From: Amanda Scholes on behalf of Planning.Responses
Sent: 12 March 2018 09:28
To: Planning Scanning
Subject: FW: 12 Raleigh Road

From: Mark Jones
Sent: 12 March 2018 08:46
To: 'Gary Smith'
Subject: RE: 12 Raleigh Road

Proposed Garage and Utility room. 12 Raleigh Road, Bognor Regis, West Sussex.
Proposed Ground Floor and Roof Plan. Drawing Number = 10 Scale 1:100 @ A3

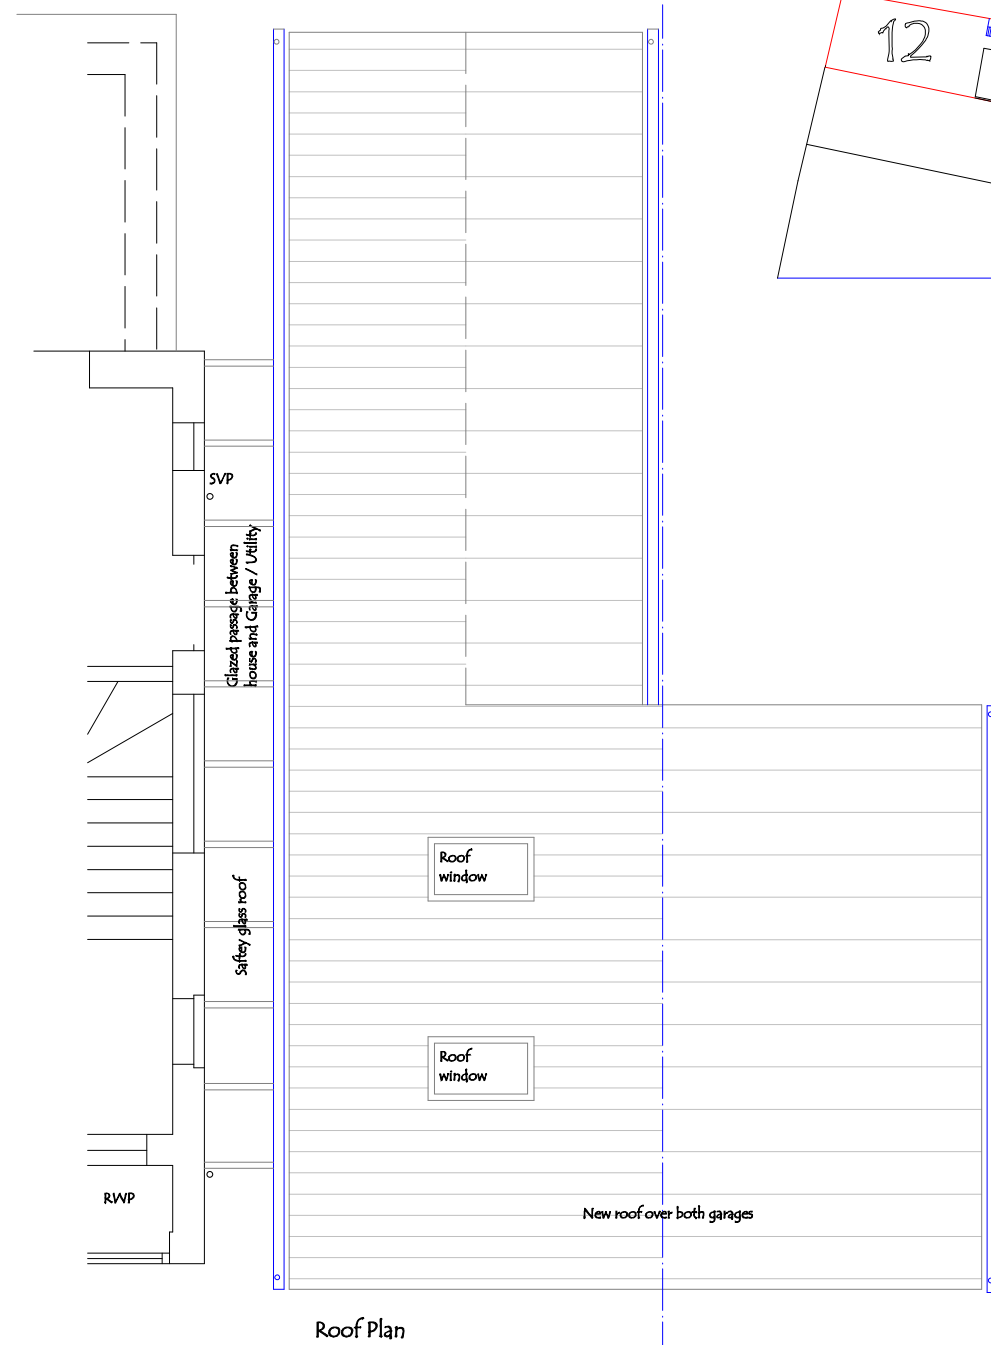
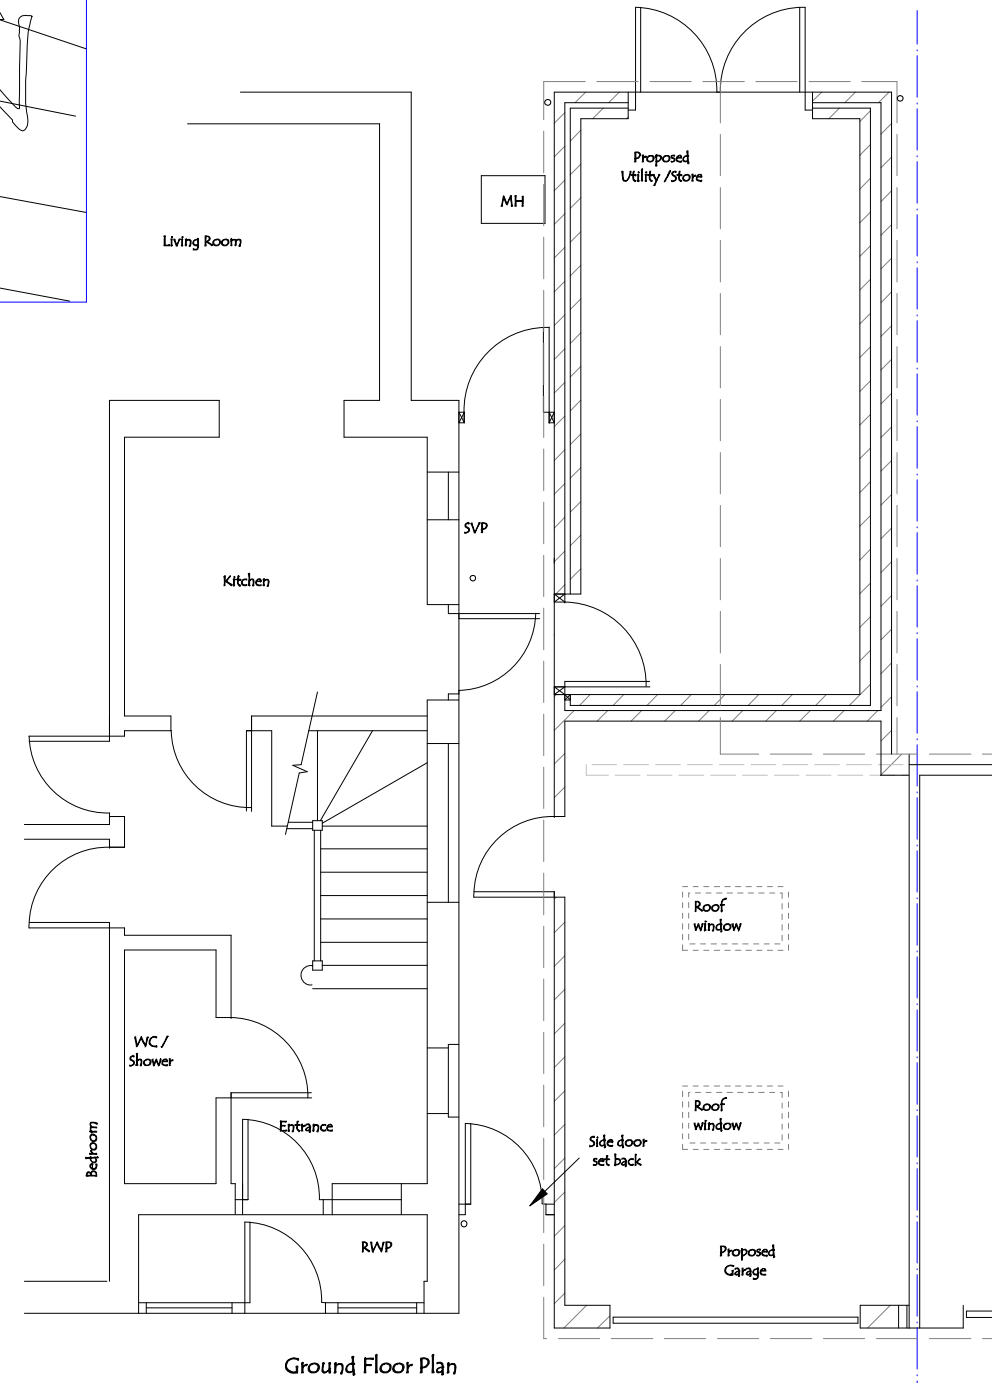
1. The plans are amended to remove the proposed roof on the neighbouring property No.10 and make a separate application for No.10 or leave No.10 out of consideration.

2. The application form changed to reflect 10 and 12 including the description . In addition the red line would need to change on location plan to include No.10. Also certificate B would be required if the application is in your name and notice served on the owner of No.10, as mentioned these forms can be obtained on the planning portal. We would need to agree an extension of time for the application to allow a revised application to be re advertised.

Can you confirm if the new roof over the garage at No.10 is part of the current application.

We are proposing a pitched roof across both properties in the application to enhance the appearance of both properties.
